**KIRKLEES METROPOLITAN COUNCIL  
INVESTMENT & REGENERATION SERVICE**

**DELEGATED DECISION FOR APPLICATION FOR CERTIFICATE OF  
LAWFUL DEVELOPMENT**

Reference no.: 2026/CL/90068/E

Site: Summerhill, 86, Hopton Lane, Lower Hopton,  
Mirfield, WF14 8JS

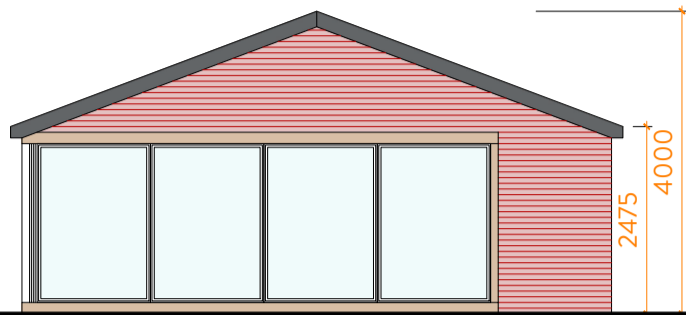
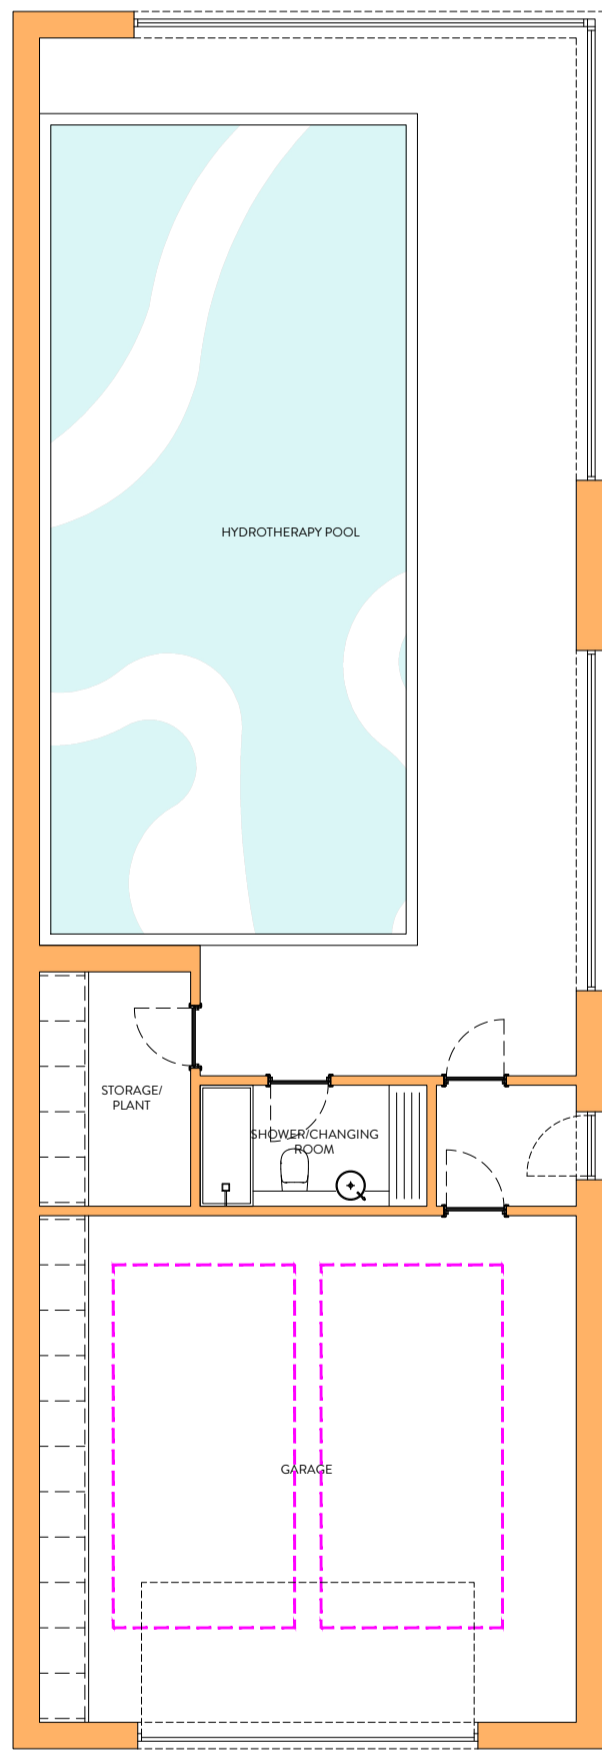
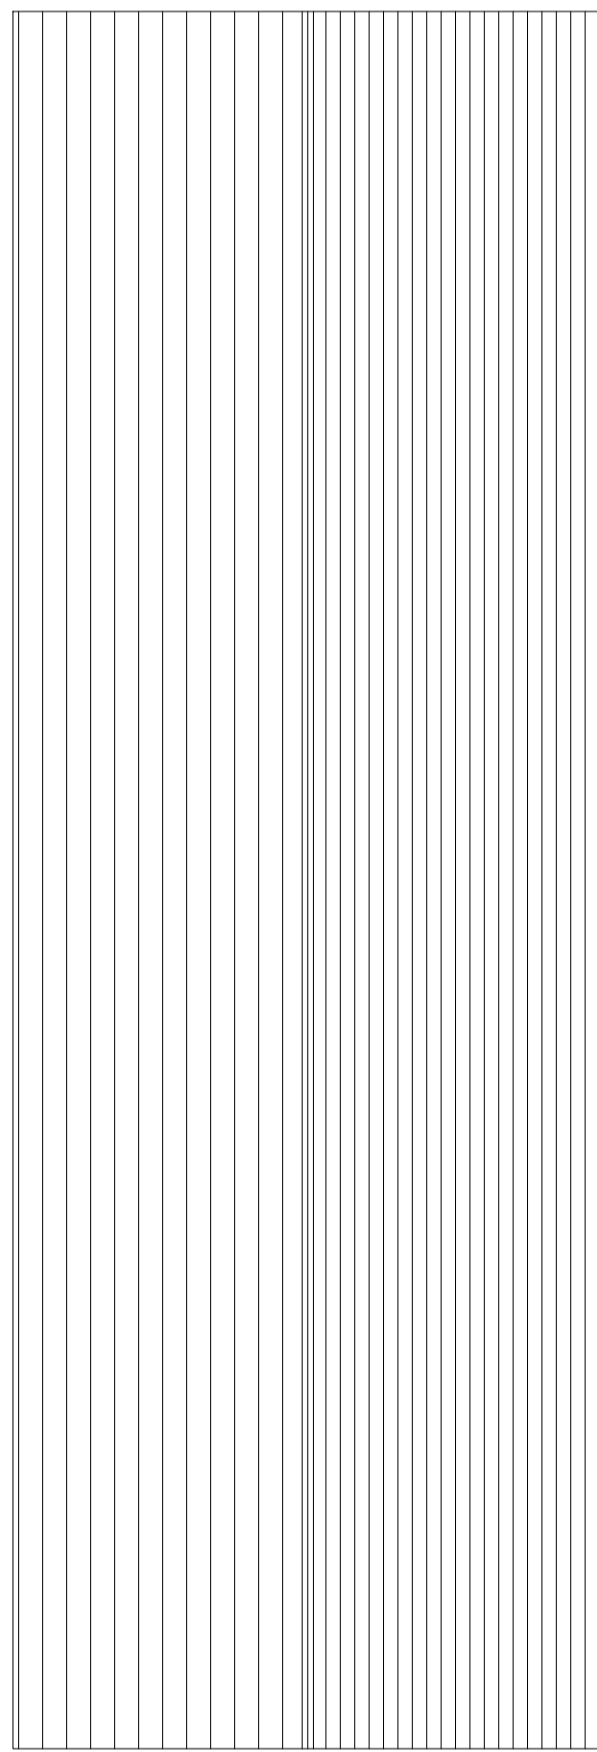
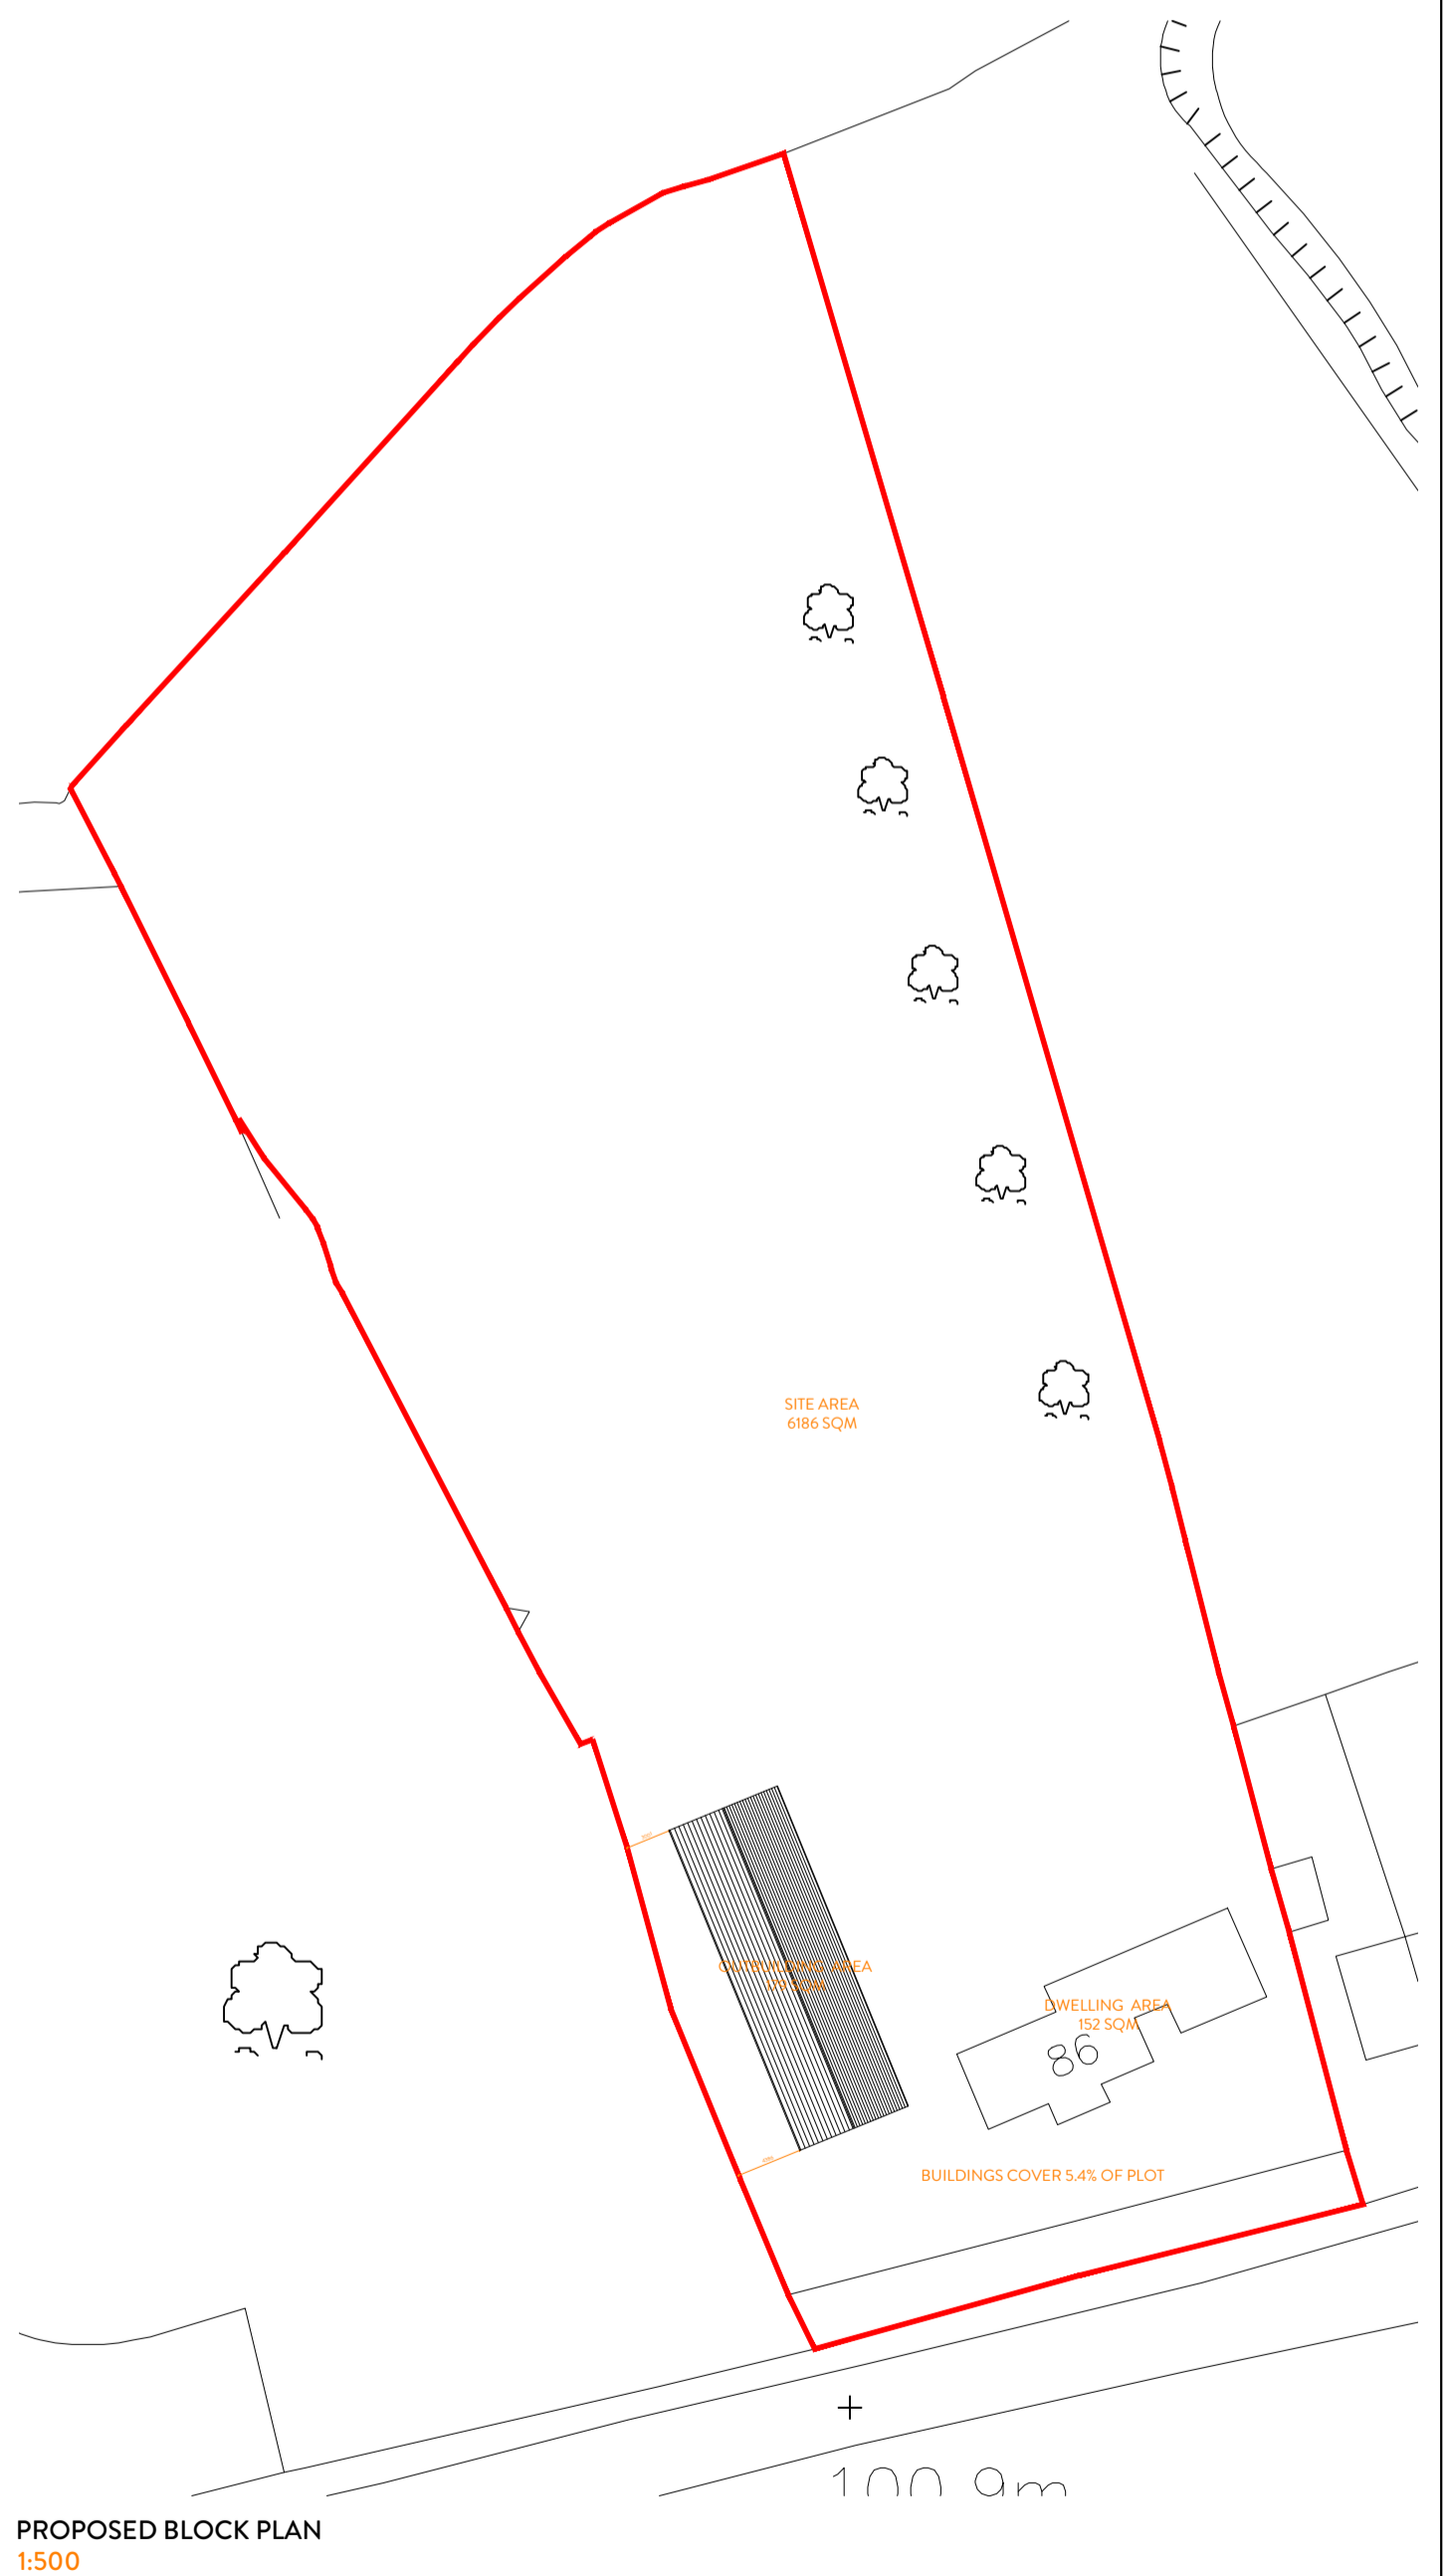
The outbuilding would be located within the rear amenity space of the property and would sit alongside the western boundary. The outbuilding would have a width of 7.8 metres and would be a depth of 23 metres. The outbuilding would have a pitched roof with an eaves height of 2.475 metres and overall height of 4 metres.

**Comment:** *The building would not be within 2 metres of the boundary and would not exceed 4 metres in height with a dual-pitched roof.*

**Comment:** *The height of the eaves of the building would not exceed 2.5 metres.*

The area of accommodation indicates that the building would be used for a hydrotherapy pool, double garage with a storage/plant area and shower/changing room. It is noted that proposed internal accommodation is similar to that previously refused albeit with the garage accommodation replacing the previously submitted sensory room. Notwithstanding the change in internal accommodation, other works may be required to provide vehicular access to the building. It is noted that whilst garage provision is proposed, the property itself hosts an integral garage and a large forecourt.

Whilst the requirements of the accommodation could be acceptable in principle, in the absence of any evidence in terms of how these calculations have been determined and in the absence of any relevant supporting information it has not been demonstrated that the sheer size of the proposed building which has a footprint over 1.17 times the footprint of the main dwelling is 'reasonably required'.

However, it has not been evidenced that the size of the building is reasonably required for the purposes incidental to the enjoyment of the dwellinghouse.
